Rezoning Transportation Analysis

Petition Number: 2020-046

General Location Identifier: Tax ID 20103128

Rezoning Site Plan

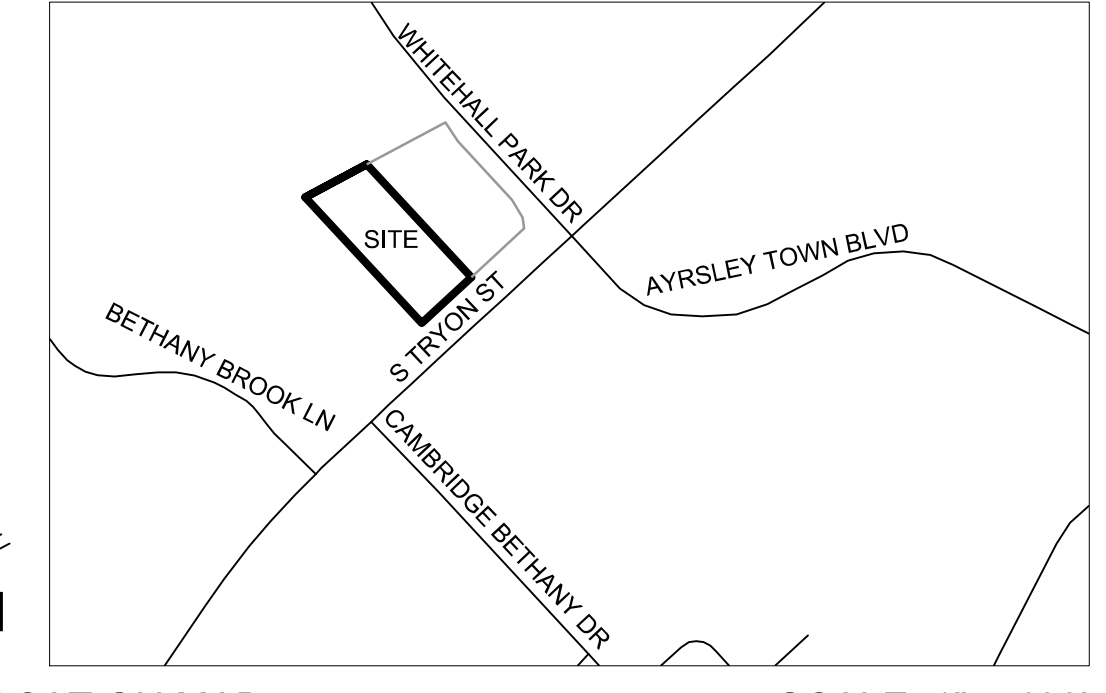
- 3. Technical Correction Site Plan (5/28/2020)** The petitioner should revise the site plan and conditional note(s) to preserve the existing driveway as **right-out only**. Per NCDOT, a right-in/right-out driveway will affect the functionality of the intersection. Please provide CDOT with any other correspondence that the petitioner has had with NCDOT, since plans to convert this access to right-in/right-out were already submitted to the city for permitting review within Accela: LDC-2019-00062 - Leon Whitehall.
